REVISION RESPONSE LETTER

**RE: River Bend Crossing Commons
Final Plat**

DATE: March 4, 2020

PROJECT No.: 17-054 SHEET 2 OF 4

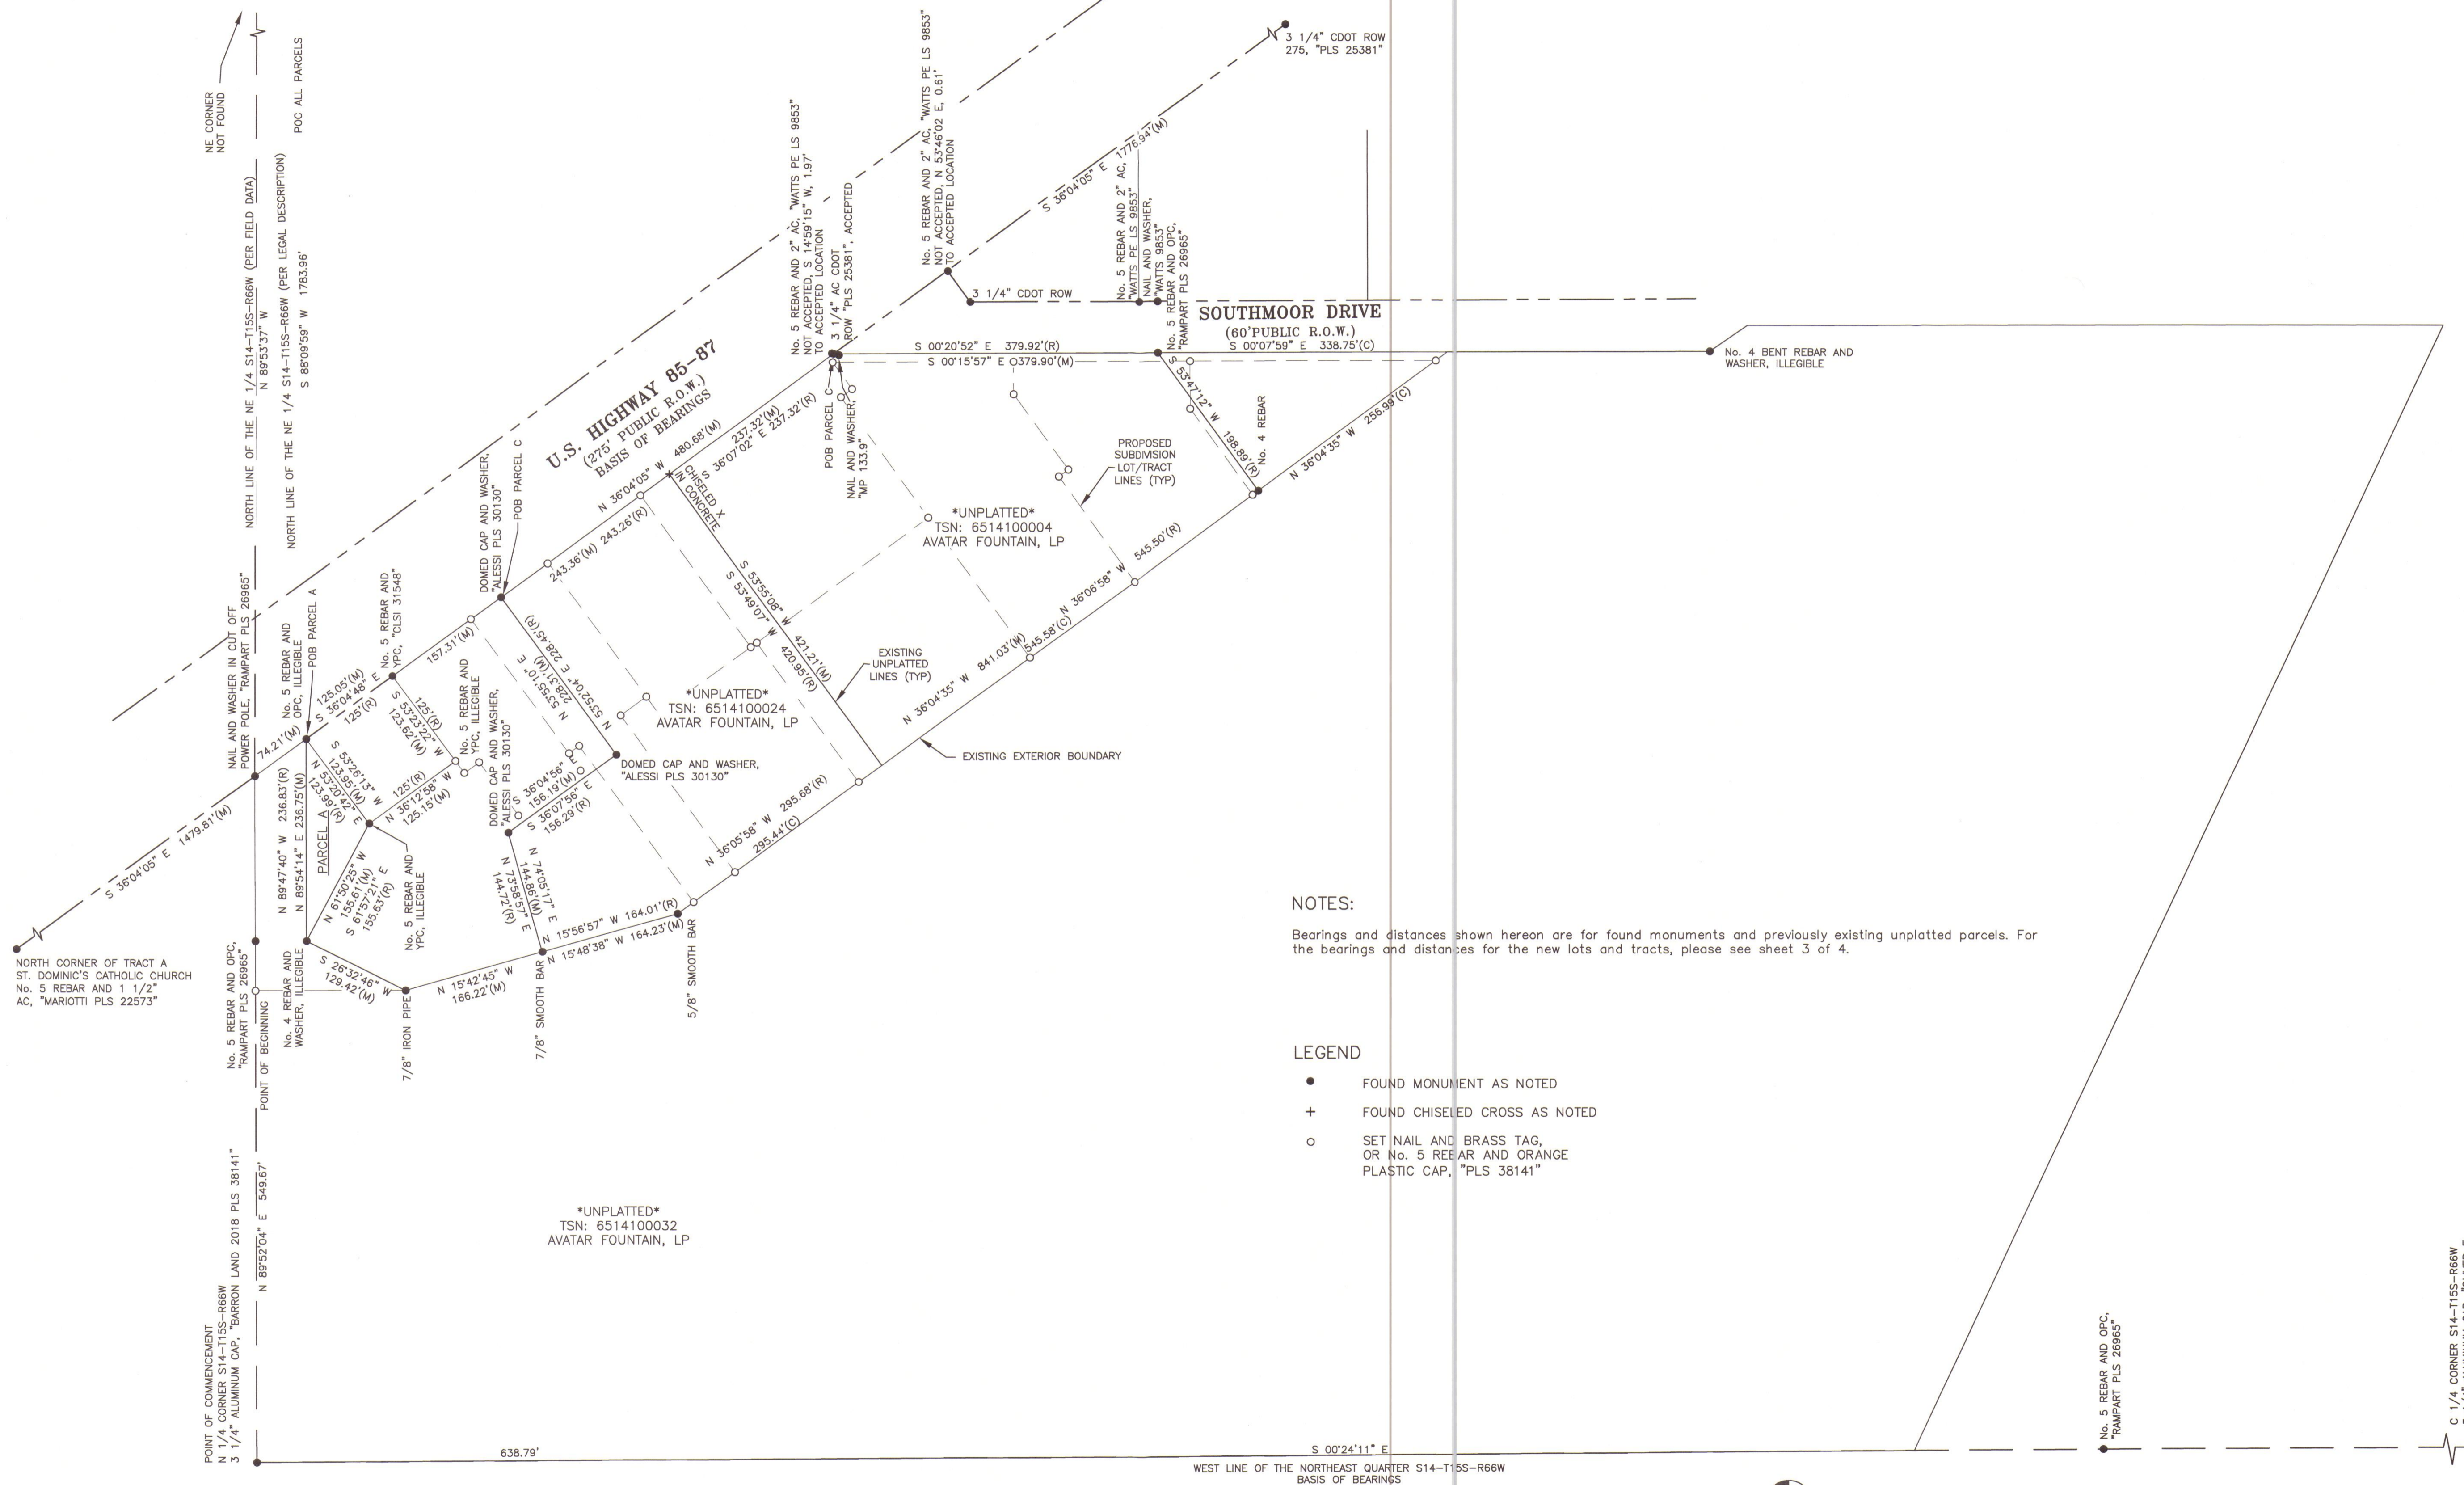
1. *Lot distances do not add up to the 637.99' total along the northeasterly boundary. Please revise as necessary. – **Item has been addressed.***
2. *Please label the tract to the northwest of Main Street – **Item has been addressed.***
3. *Lot distances do not add up (Tract A, Main Street, Lot 2, Tract B, Tract C, Lot 4, Lot 5) along the southwesterly boundary. Please revise as necessary **Item has been addressed.***

PROJECT No.: 17-054 SHEET 4 OF 4

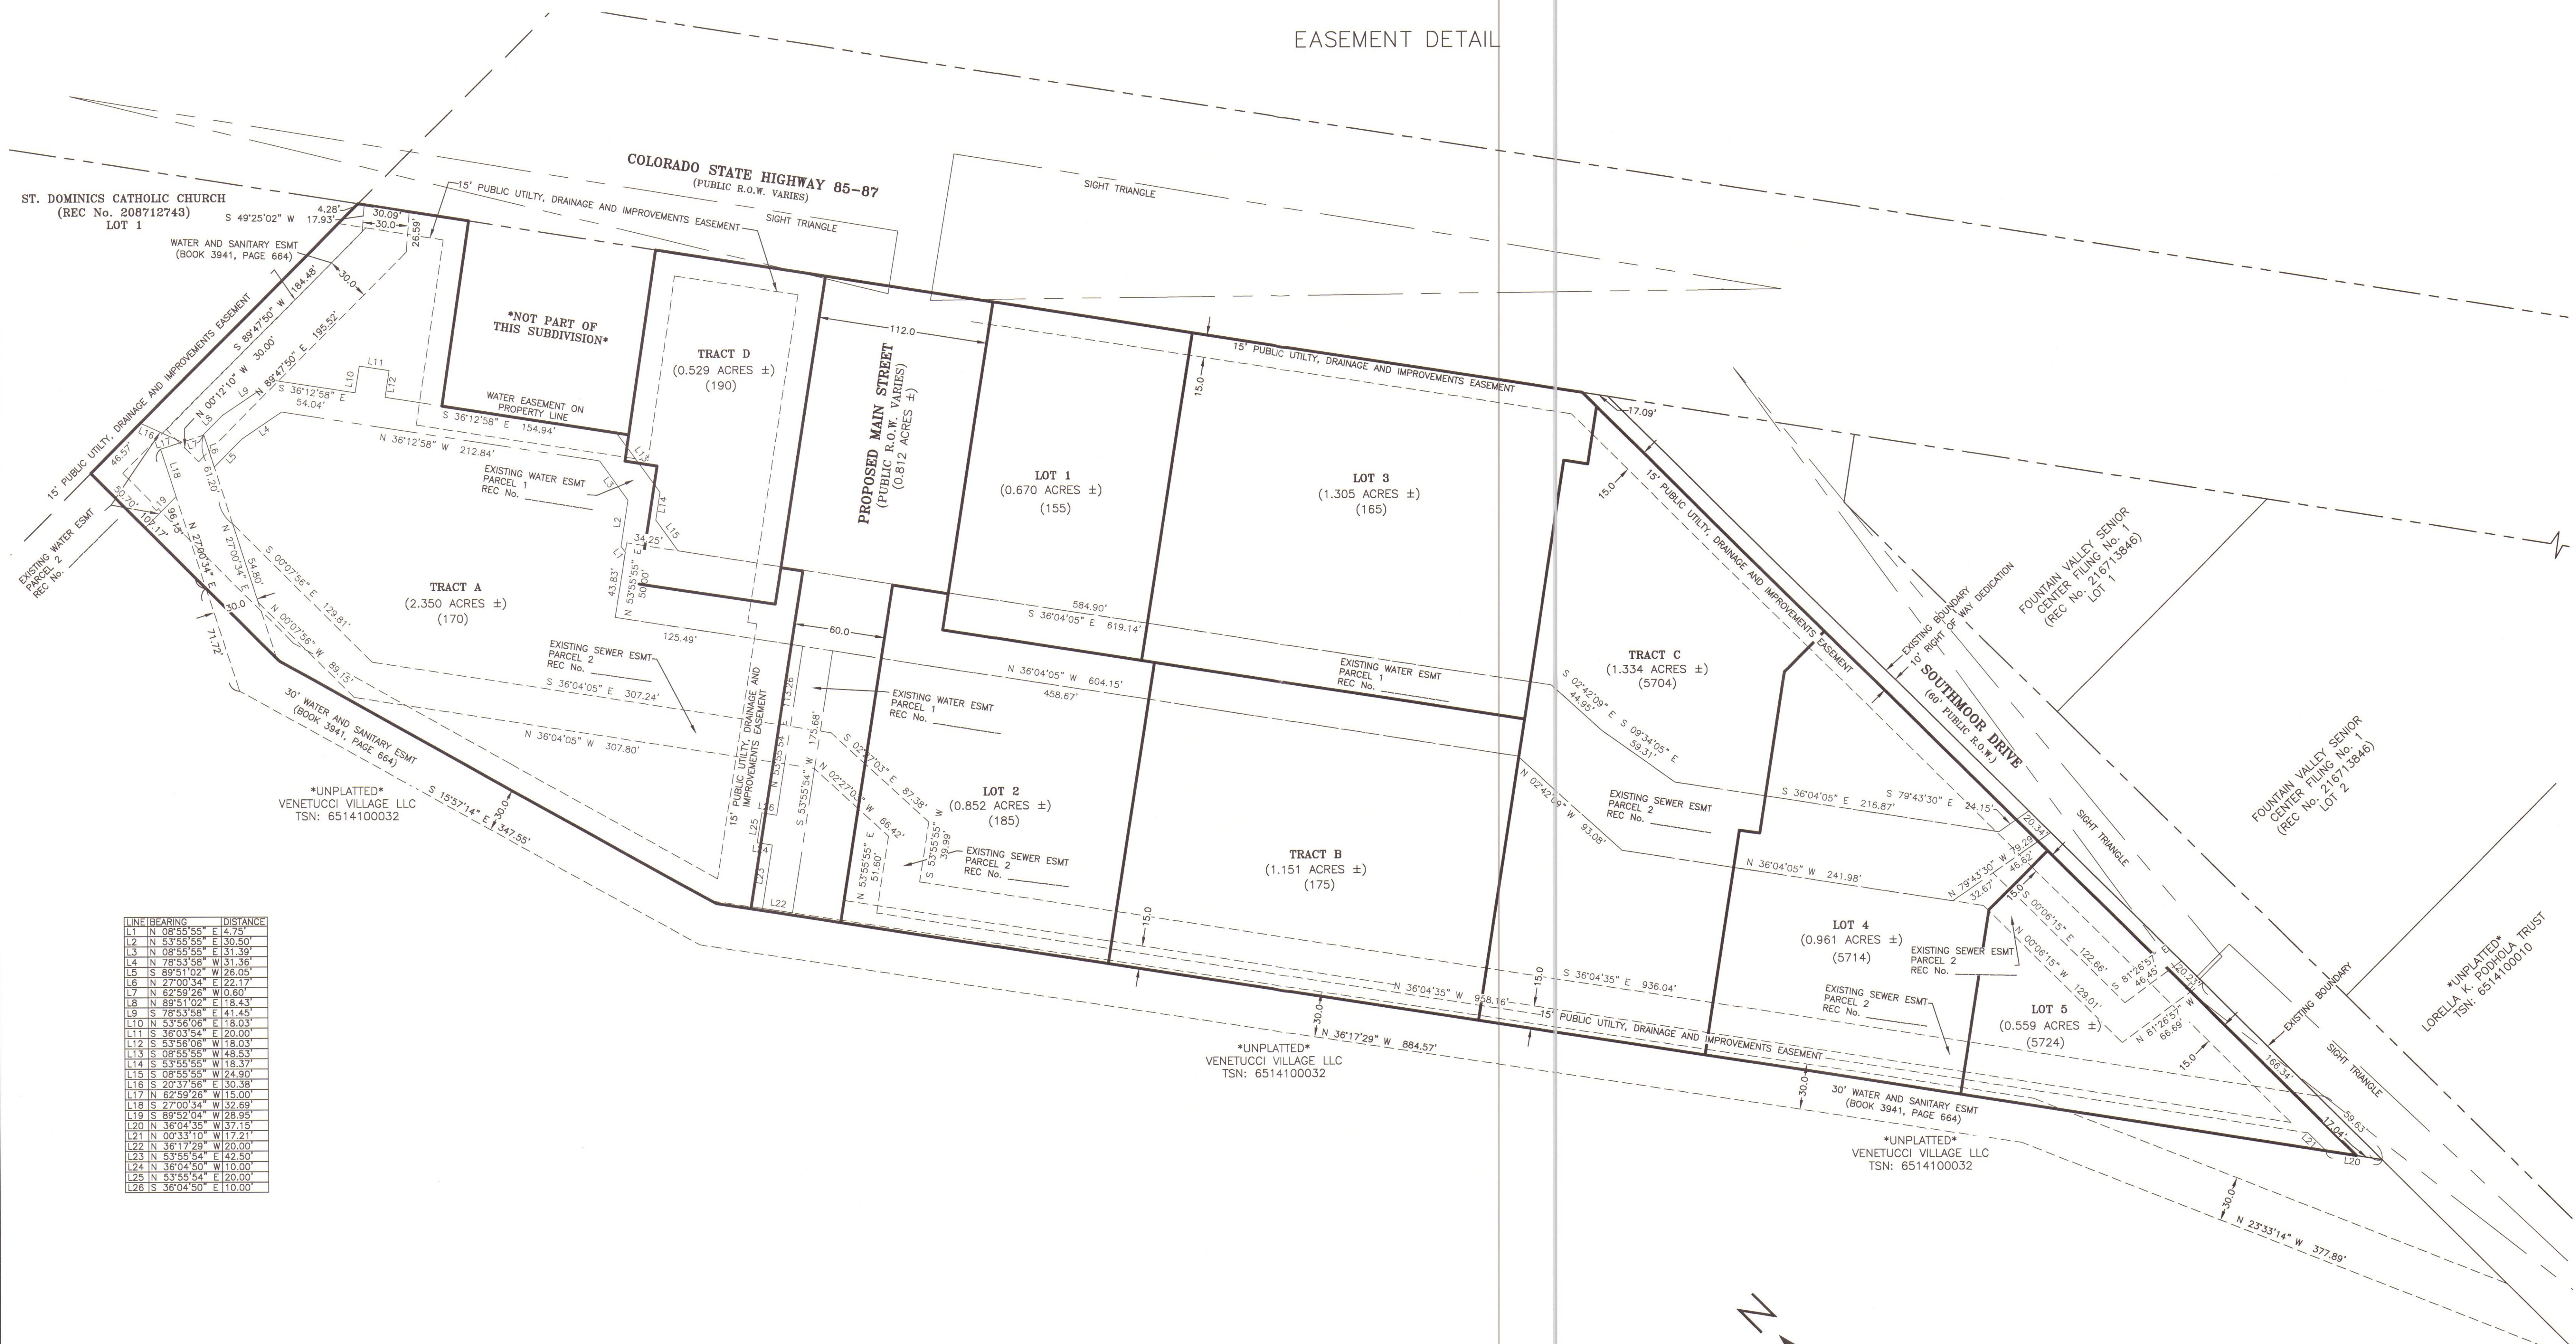
1. *Corner monumentation not shown on Sheet 3. Please revise.*
All monumentation are shown for this project on sheet 2 to reduce the clutter and so everyone can see them all as a whole. Sheet 3 is not for the monumentation of the project
